SHOALHAVEN CITY COUNCIL
ENVIRONMENTAL ASSESSMENT SUBMISSION TO THE NSW DEPARTMENT
OF PLANNING PART 3A, ENVIRONMENTAL PLANNING & ASSESSMENT ACT, 1979

MAJOR PROJECT APPLICATION MP 06_0205

Vincentia District Centre
Modification No 5

PROPOSAL: Proposed MP06_0205 VDC Stage 1 - Modification No 5 being a modification to the VDC Stage 1 approvals issued in Modifications 2, 3, and 4.
Delivery of the VDC in two stages with an amended floor layout design and Statement of Commitments and proposals for a fuel and fast food outlet in Stage 1.

Master Plan (December 2011) - DSEWPac, OEH, NPWS & SCC

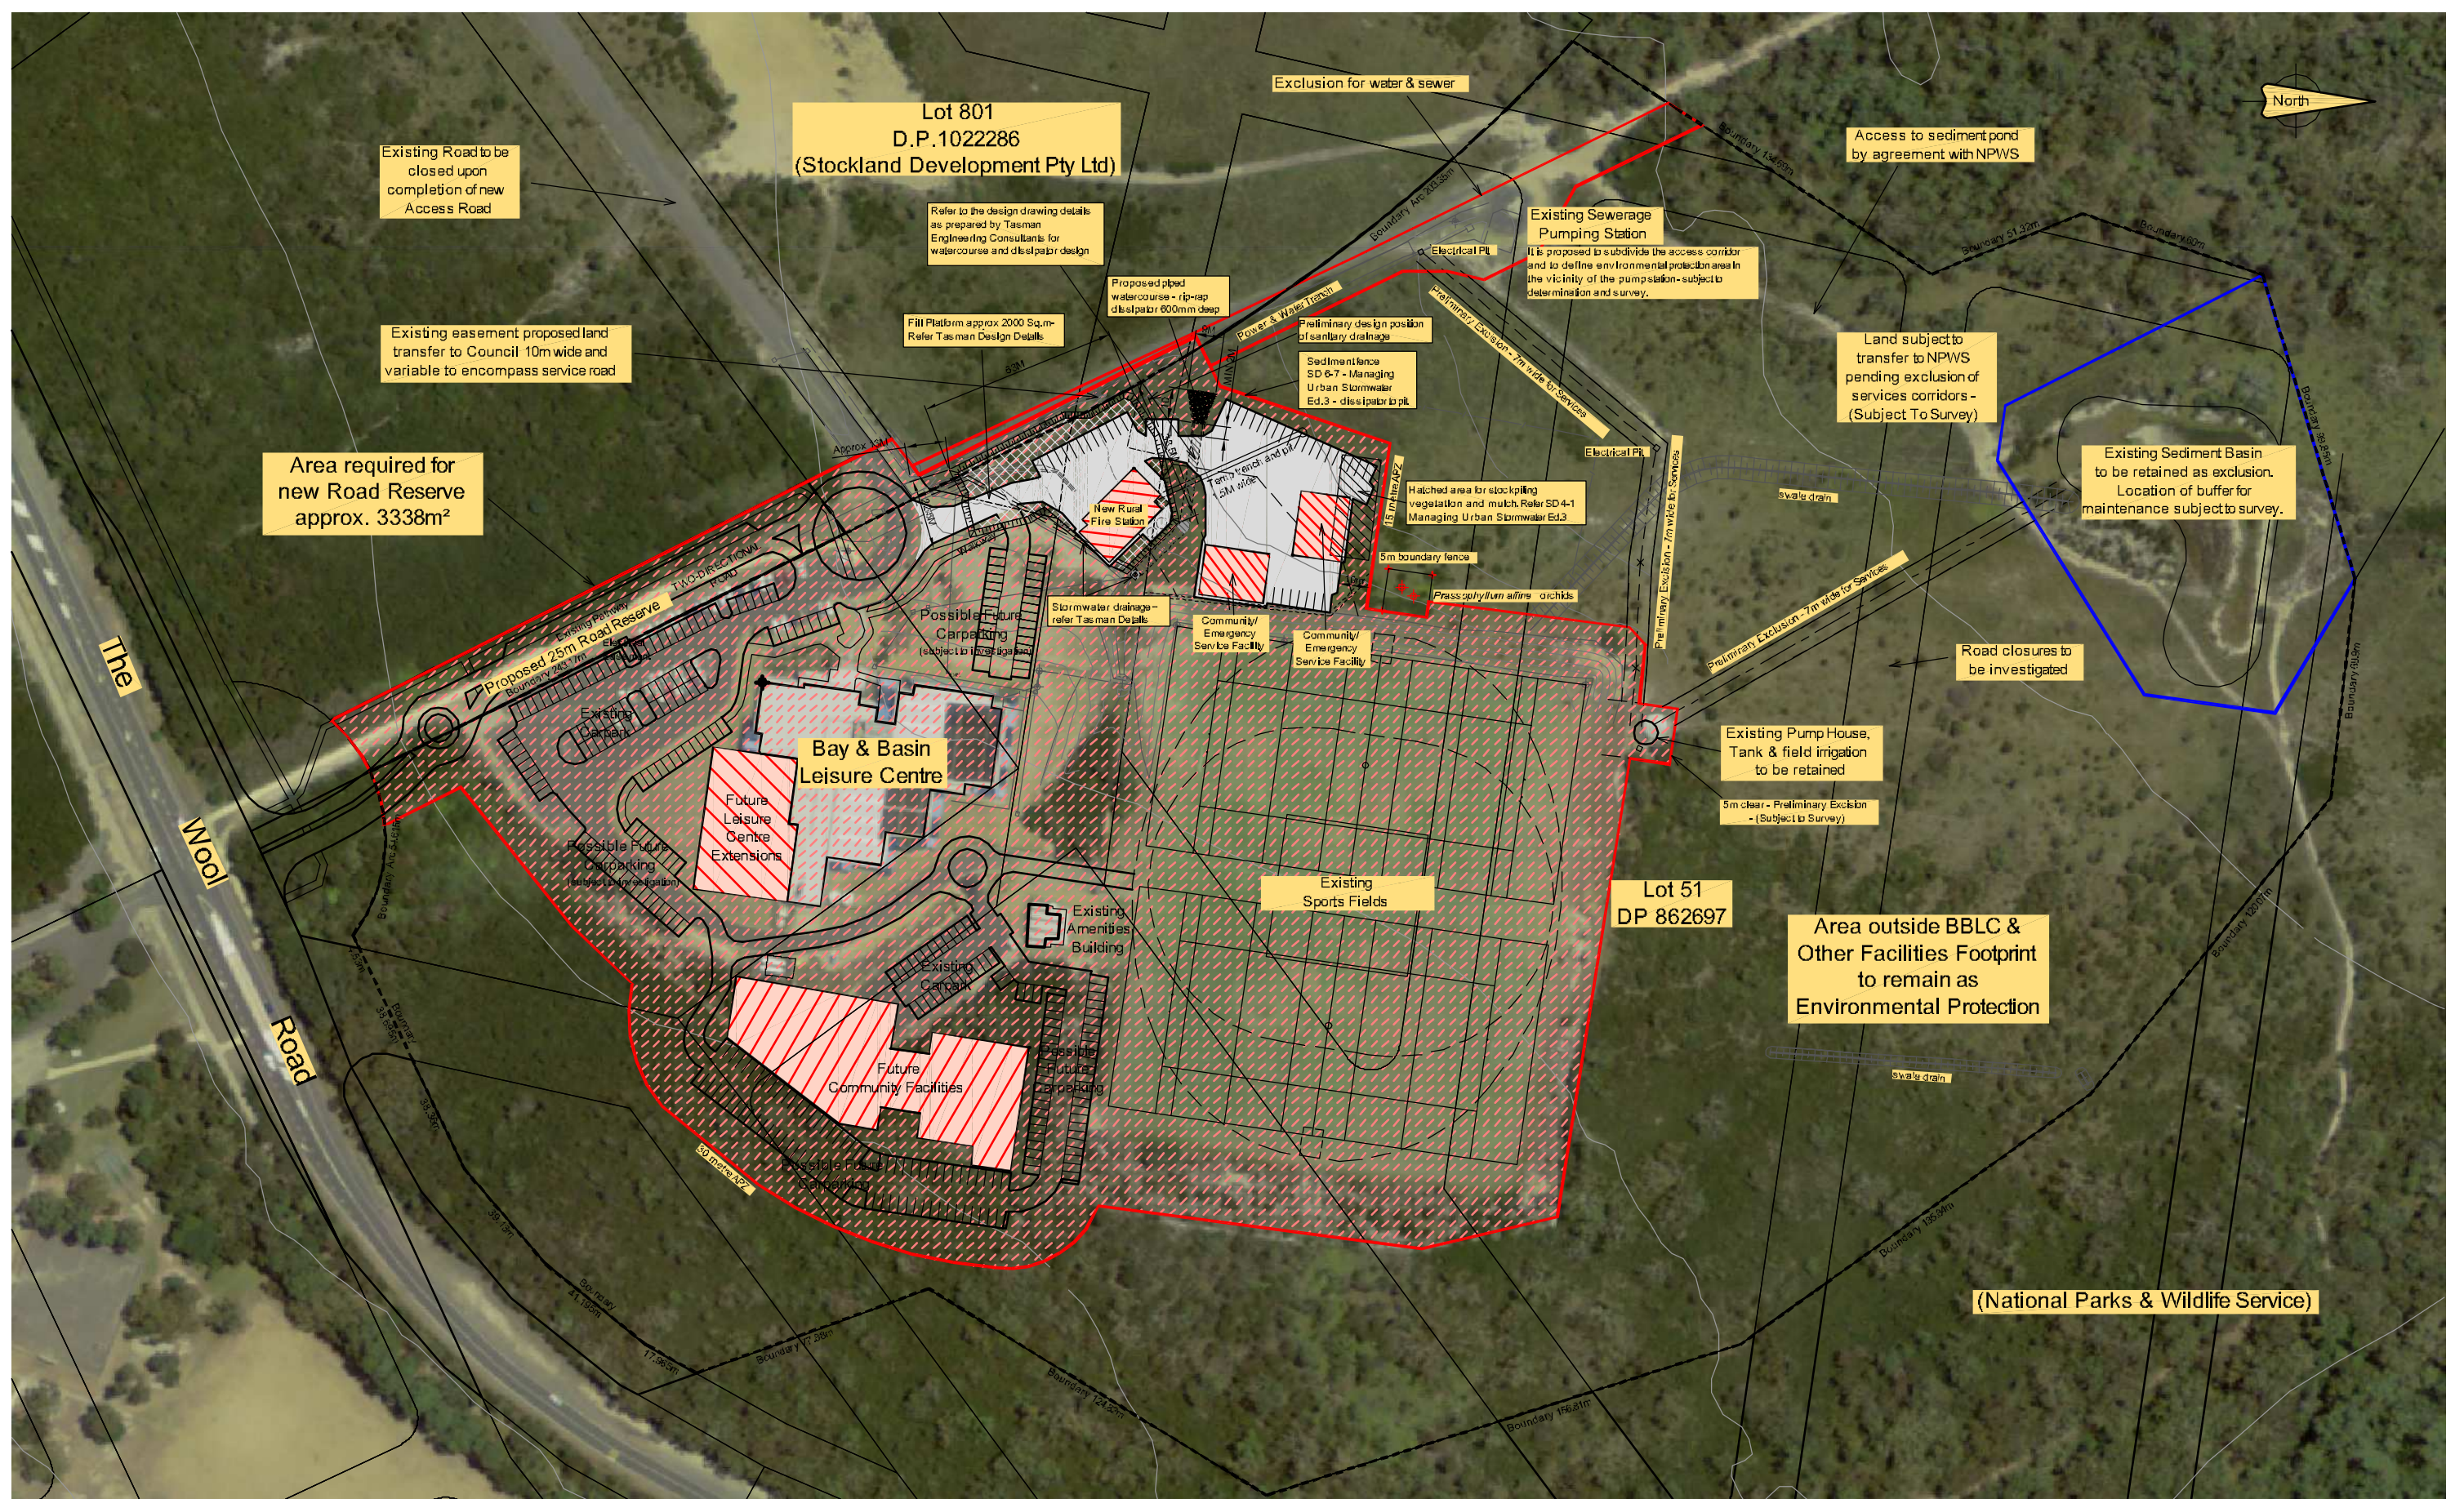
A copy of the Masterplan for the BBLC and the currently agreed new access road to the BBLC is attached as **Appendix 1**
